East Preston Parish Council
Mr Simon Cross
Council Cabin
Sea Road
East Preston
BN16 1LP

Alterations & first floor extension, providing a reduced garden room on the ground floor, together with conversion of garage to a gym & 2 new bedrooms, study & bathroom to first floor. Removal of existing pitched roof & replace with lower mono pitched roof

Sandgate House South Strand East Preston Littlehampton

Thank you for your internet representation made on 8th August 2012 which has been recorded as **an objection** with the comments as follows:

1207 SK26
 Sandgate House, East Preston
 Elevations As Proposed - sheet 2
 June 2012
 scale: 1:100

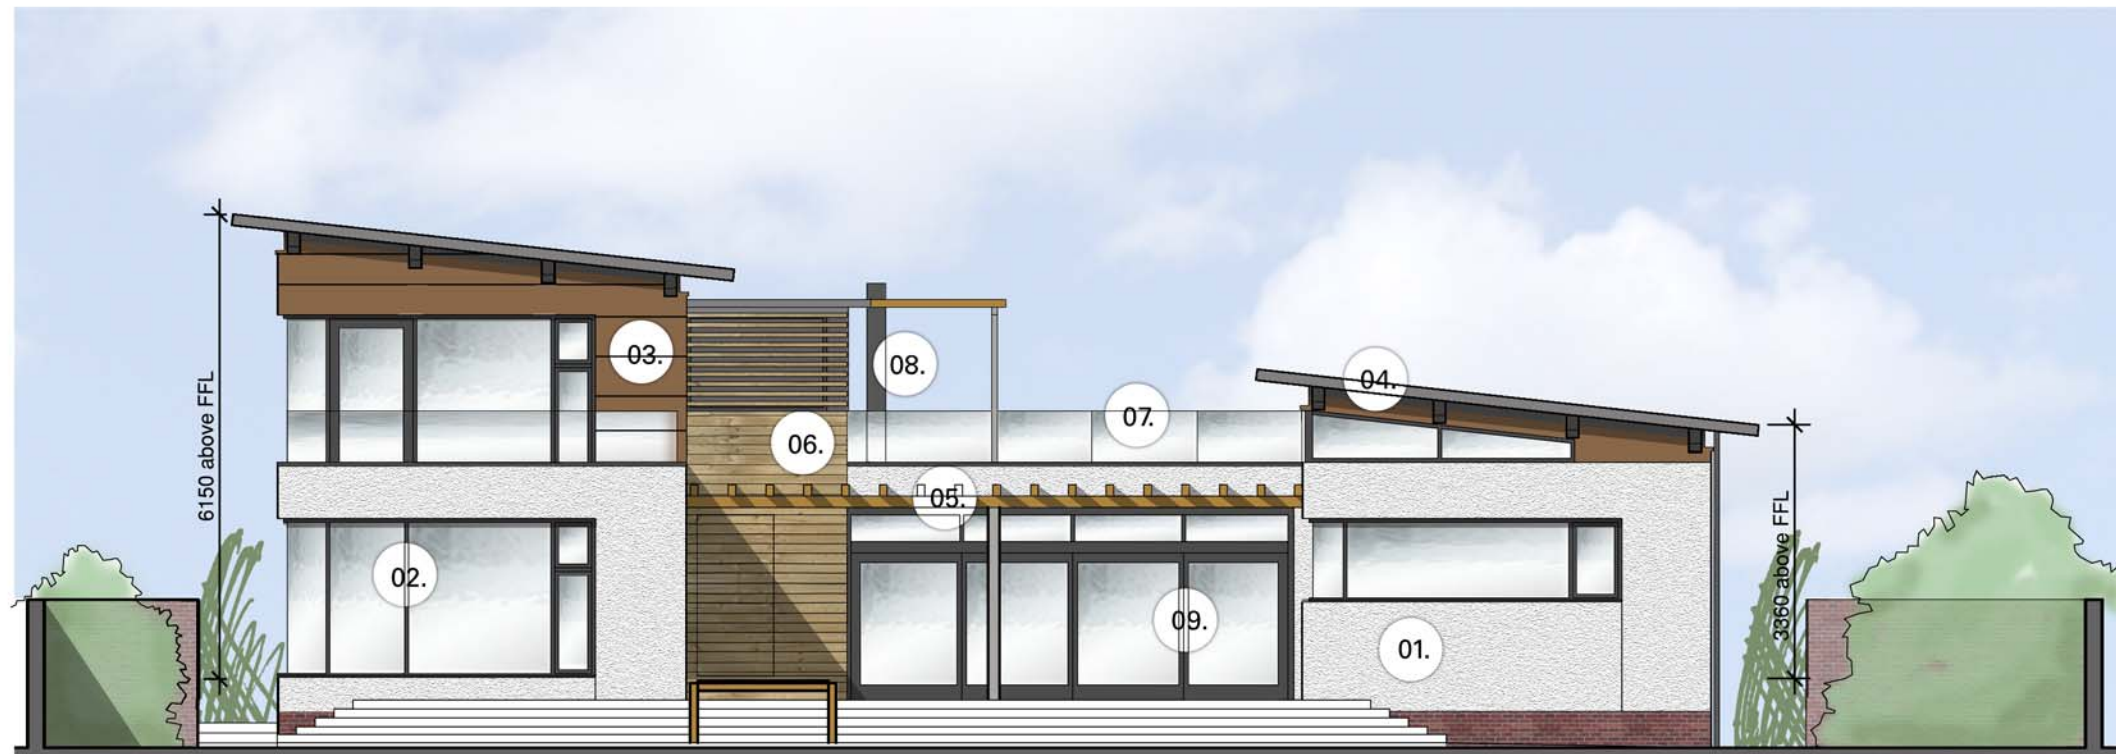
This council feels that the scale of the proposed building would have a detrimental impact upon the appearance of the locality, contrary to GEN7 and DEV19 of the current Arun District Local Plan. The modern design of the building, in such a prominent position, would be out of keeping with other properties along the foreshore. □

Section 3 of Policy DM14 in the emerging Arun Local Plan states that development should ¿(h)ave minimal impact to users and occupiers of nearby property and land.¿ This council is concerned that the proposed balconies may discomfort beach users. □

1207 SK25 A
Sandgate House, East Preston
Elevations As Proposed - sheet 1
June 2012
scale: 1:100

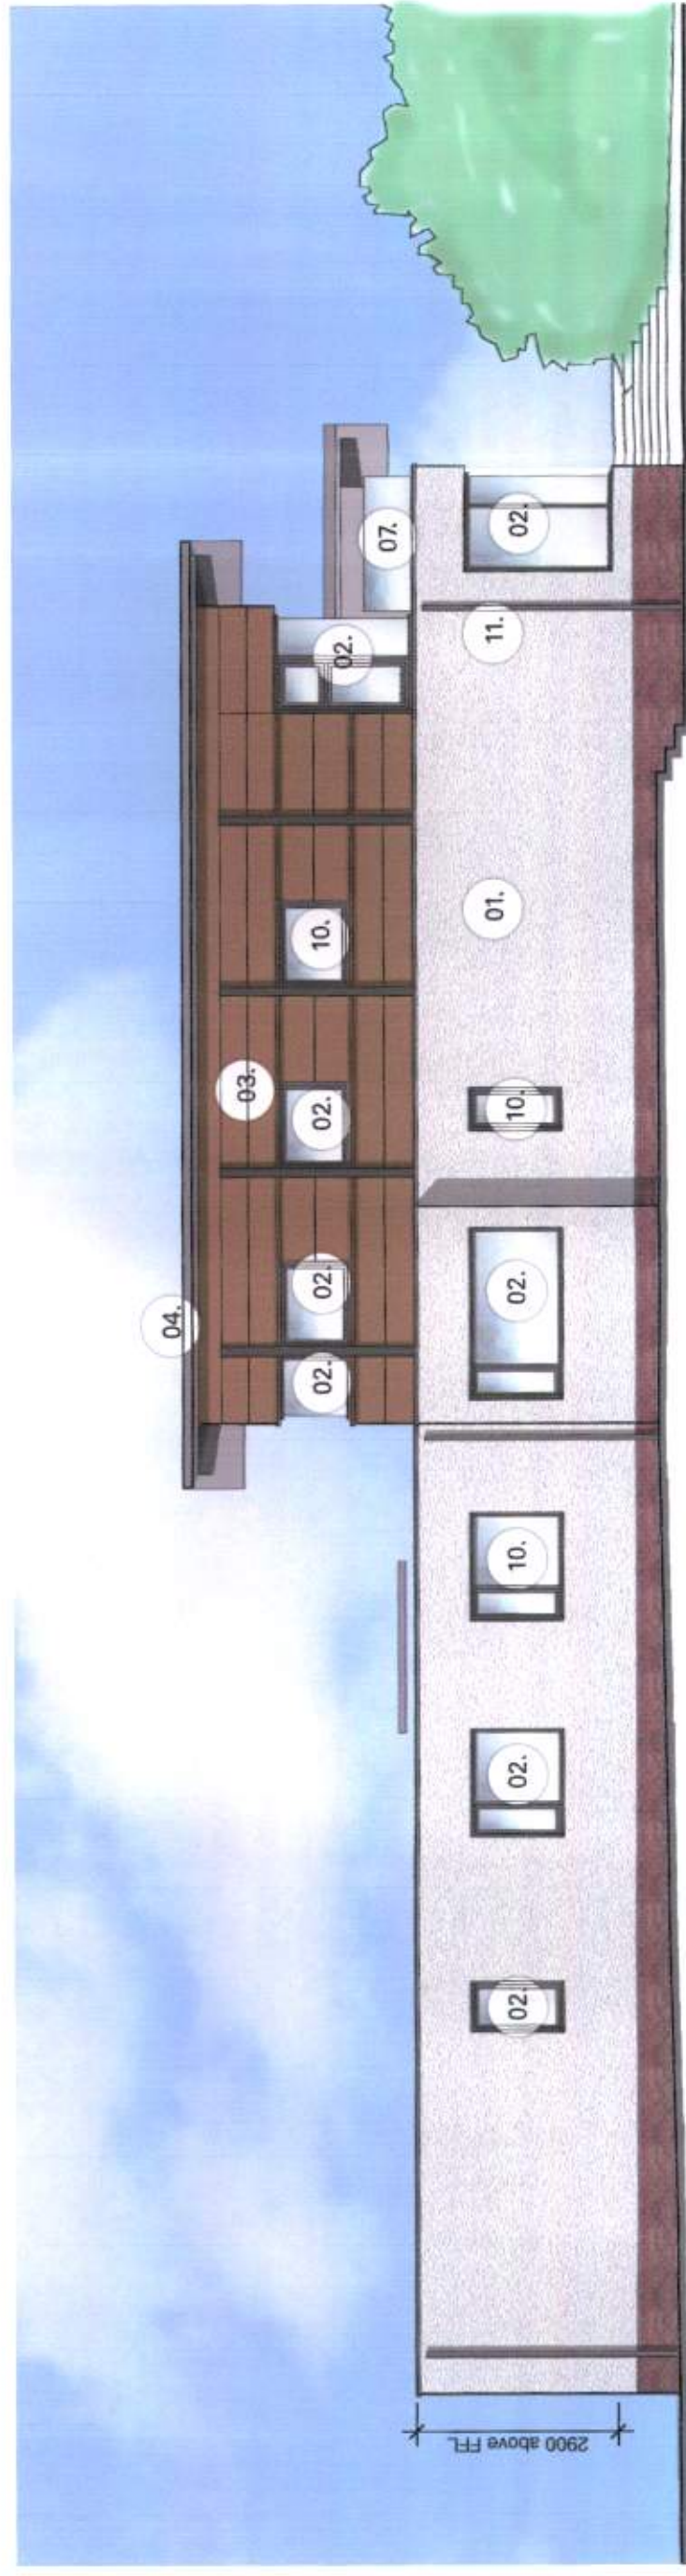
The western side of the building will be significantly higher than buildings immediately to the west of it, and this may give an unbalanced feel to the area, although it is accepted that properties further east are higher. It is expected that the design would erode the views to sea of properties to the north of Sandgate House itself. □
